Your Ref: EG/59/12

Our Ref: PLAN-001247

**Proposal: Laying of permeable hardstanding, A/C unit/enclosure, handrail and external lighting.**

**Site: 18 Elm Grove, South Barnham PO22 0EJ.**  
**EG/59/12**

TITLE SITE PLAN

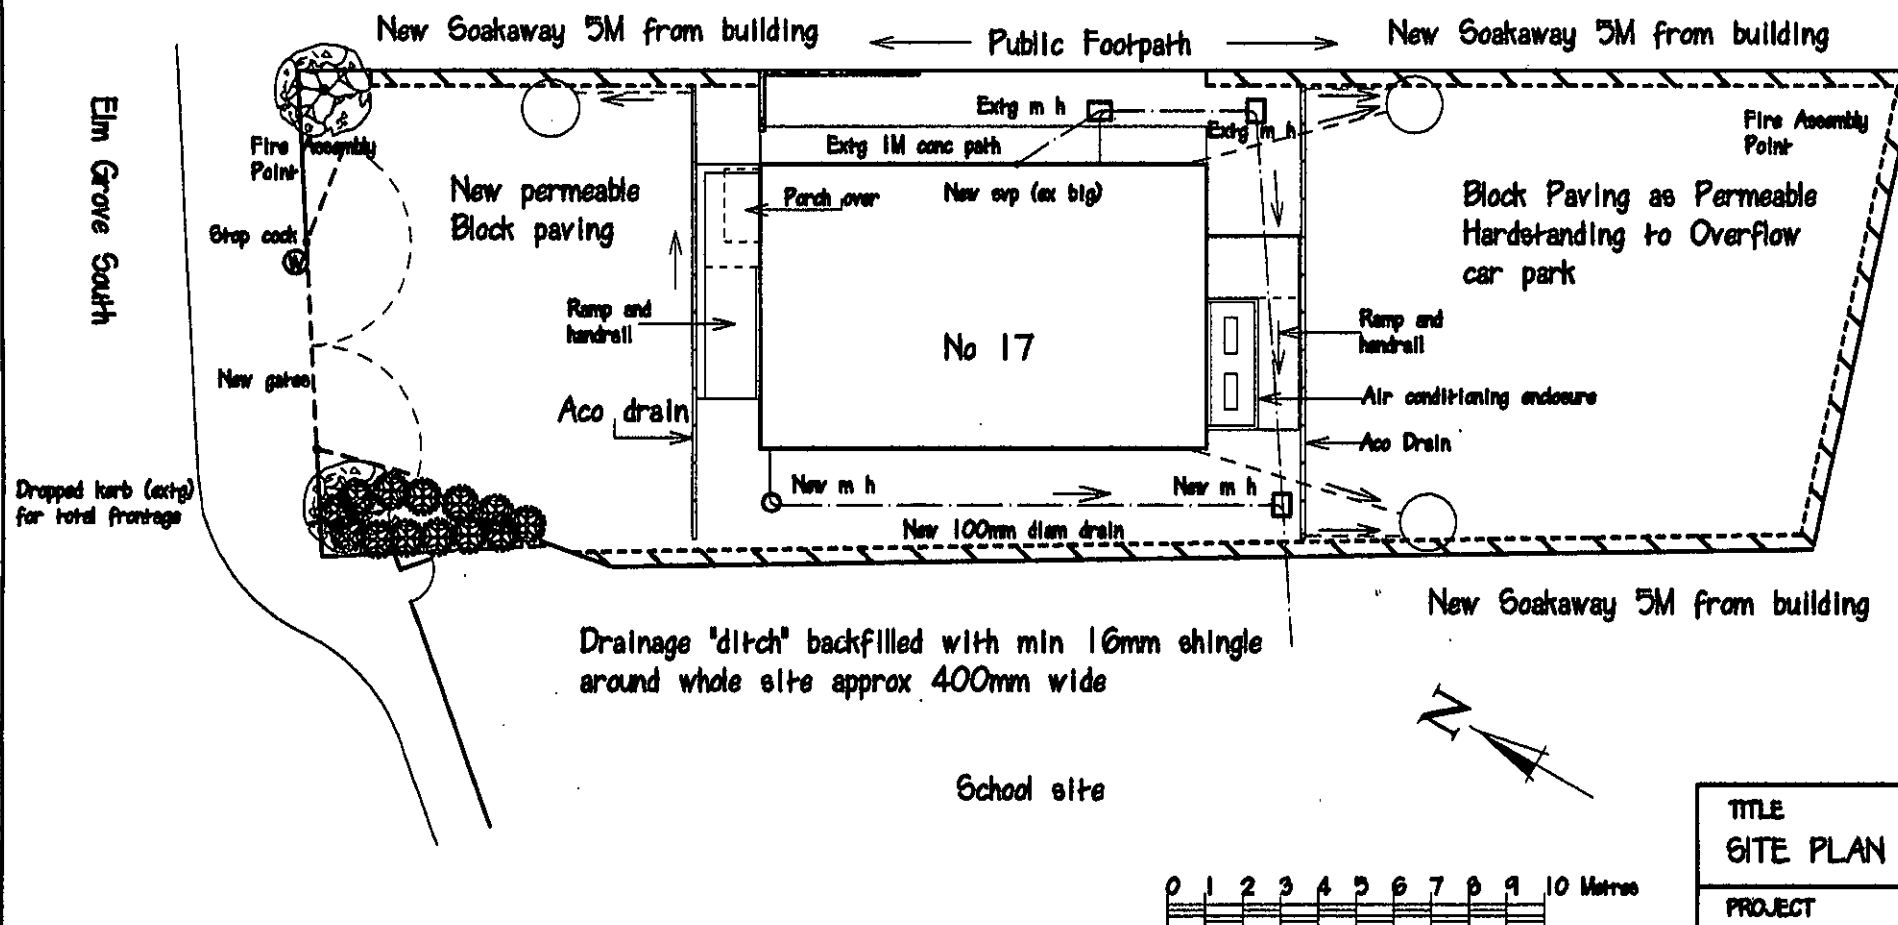
The Council's Building Control officers or technical staff should be asked to comment on the adequacy of soakaways to dispose of surface water from the proposed development.

Due to surface water inundation issues in the Lidsey Catchment "The applicant is advised to adopt, where appropriate, the measures in the table "Practical measures to reduce the potential impacts of development".

Developer should look to protect the public sewerage system from inundation and infiltration, favourable conditions.
